WEST SUSSEX COUNTY COUNCIL CONSULTATION

TO:	Arun District Council FAO: Simon Davis
FROM:	WSCC - Highways Authority
DATE:	19 June 2020
LOCATION:	The Beach Hotel, former Mud Club & 2-4 Waterloo Square Bognor Regis PO21 1SU
SUBJECT:	BR/282/19 Redevelopment into 49 No apartments consisting of 24 No 1 & 25 No 2 bed apartments & 2 No commercial units (A3 Restaurant & Cafe). This application affects the character & appearance of The Steyne, Bognor Regis Conservation Area & may affect the setting of a listed building. More information received.
DATE OF SITE VISIT:	29 March 2020
RECOMMENDATION:	No Objection

- 001** Access Overview and Swept Path Analysis
- 002** Servicing Vehicle Swept Path Analysis
- 003** Car Parking Swept Path Analysis

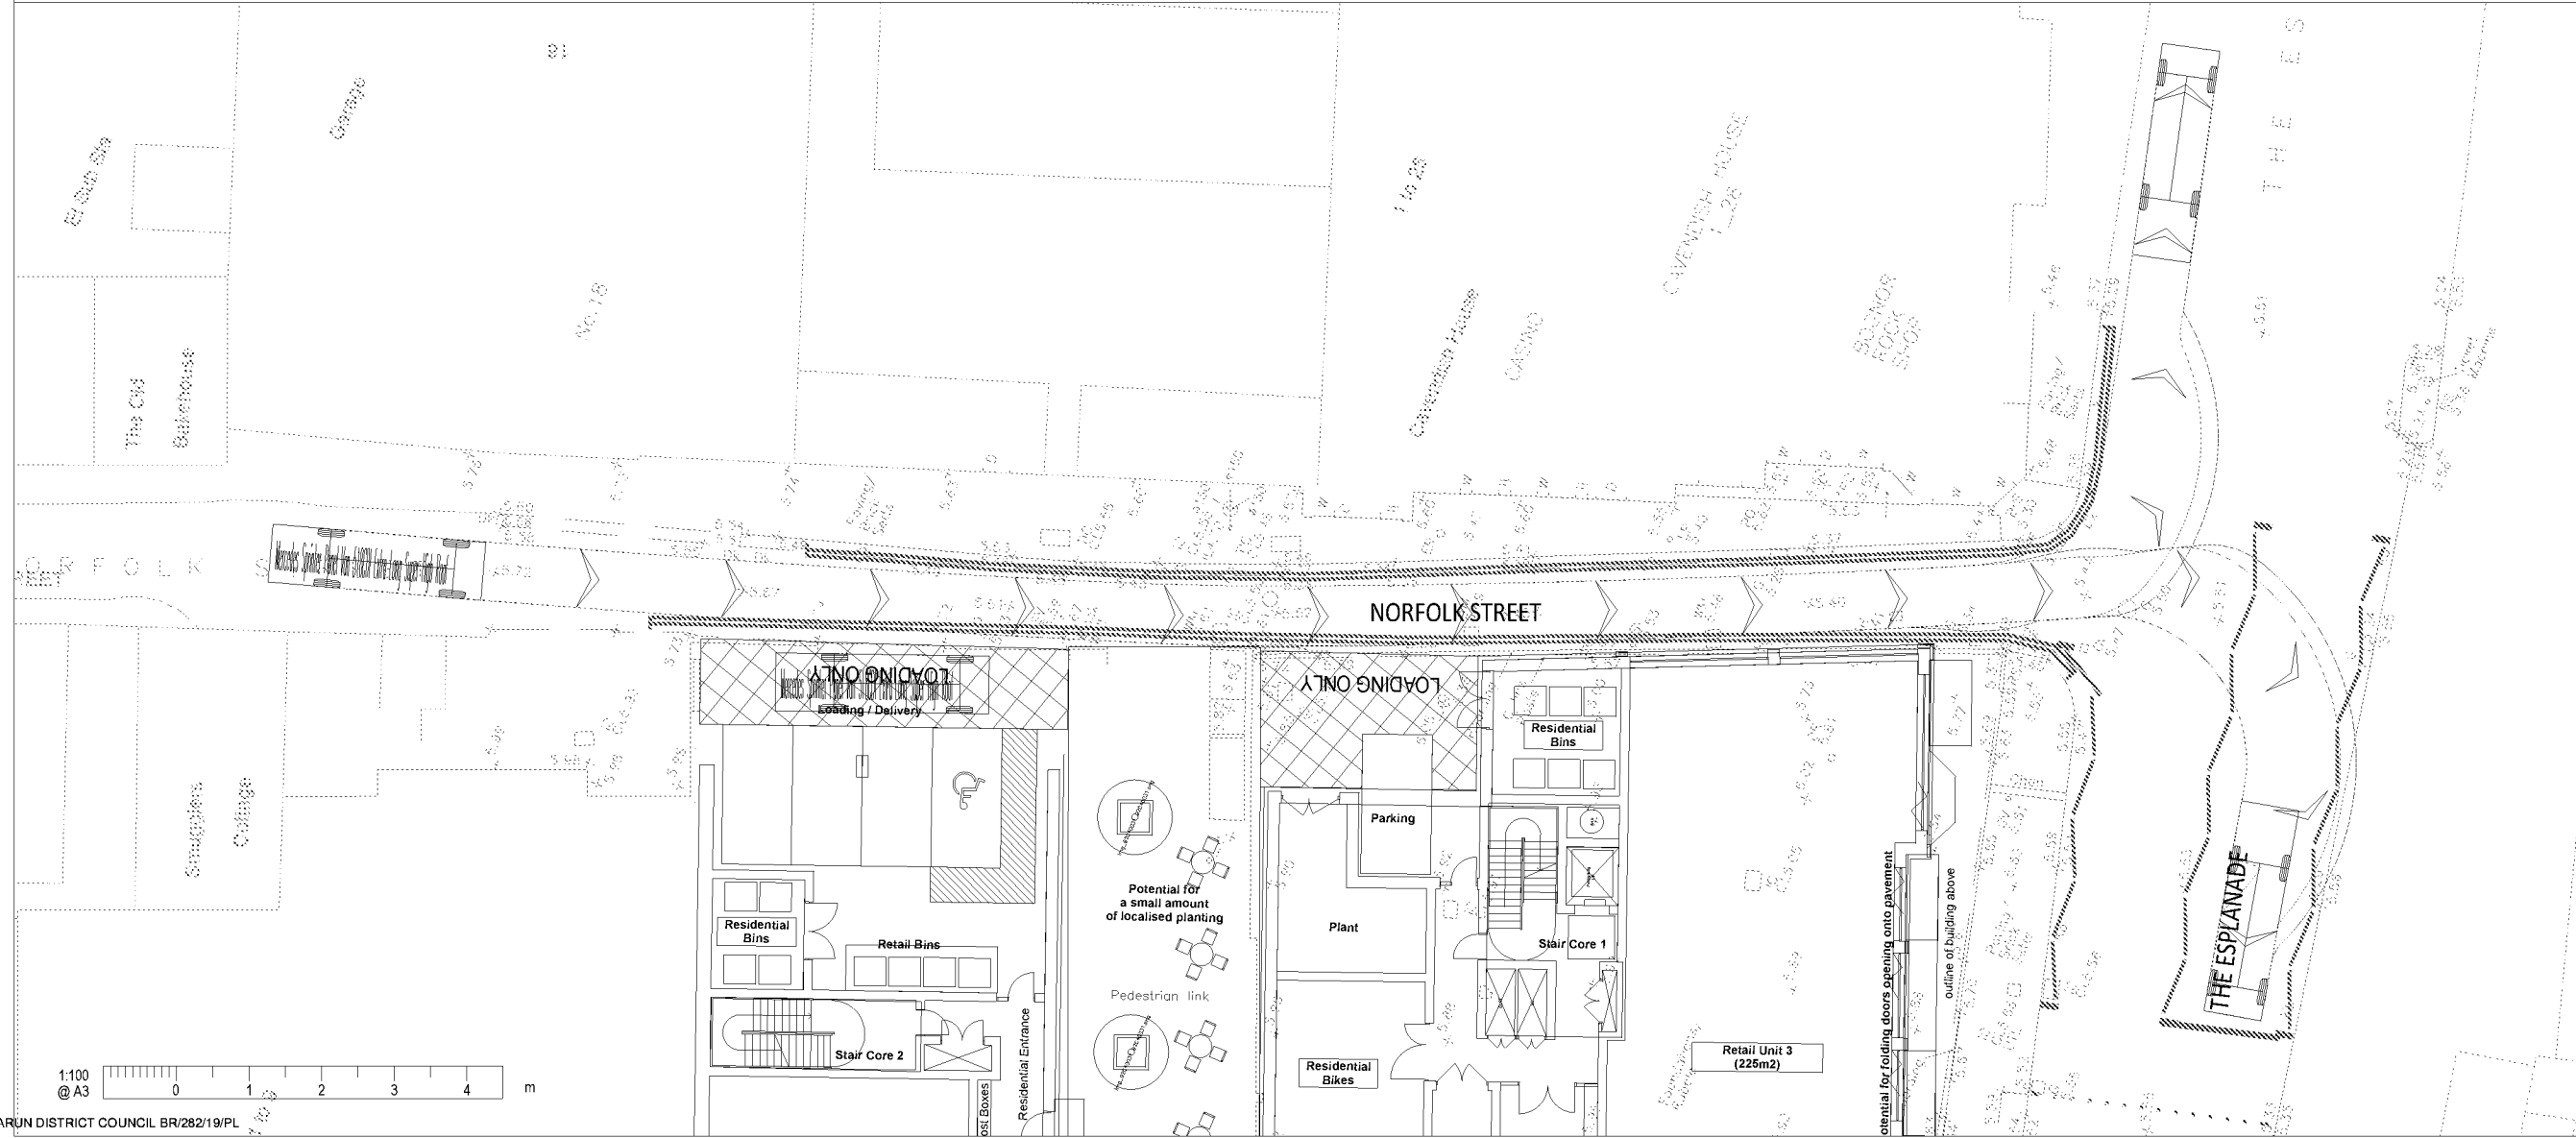
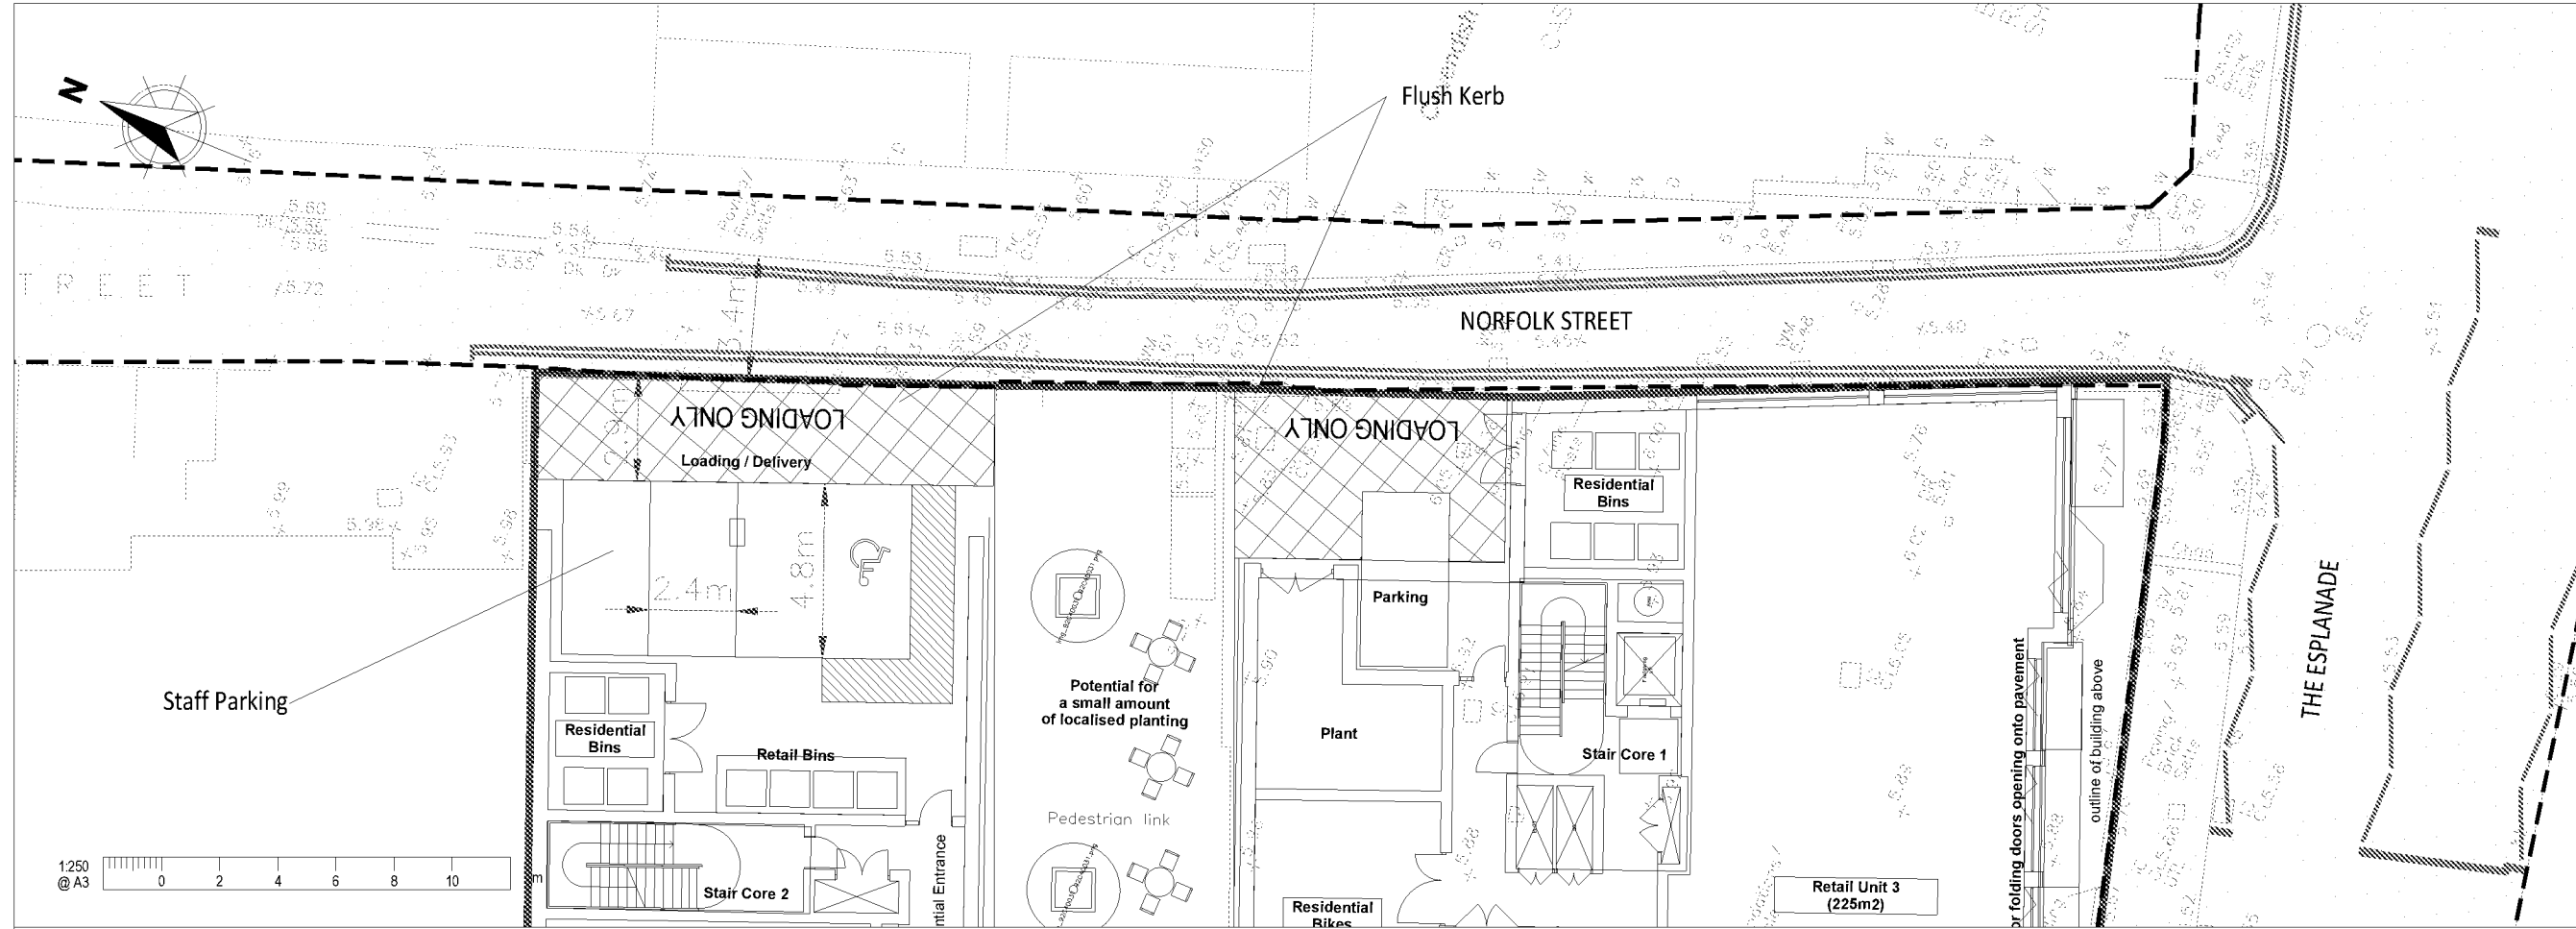
An RSA has been carried out on the amended access arrangements from Norfolk Street, to GG119 standards. The RSA raised one problem in relation to the northern end of the development access where a risk of side swipe collisions was identified. The auditor recommends that boundary treatment is less than 1.05m to allow exiting drivers unobscured visibility (over bonnets of cars parked to north). It is acknowledged that parking spaces are limited for staff only and thus vehicle movement to and from these spaces is considered infrequent. The Designer has responded with acceptance of the problem and recommended solution and has clarified that any boundary treatment will be kept below 1.05m. The proposed plans appear to indicate no obstructions at the site boundary which will be kept clear. The LHA request that the Designers Response is sent in the accepted format as per table F4 and F5 in GG119 so that a formal signed log can be recorded.

The LHA consider that outstanding issues have been suitable addressed from a highway safety and capacity point of view. The only outstanding point at this stage is request for the designer to send the Designers Response in the accepted format as per table F4 and F5 in GG119.
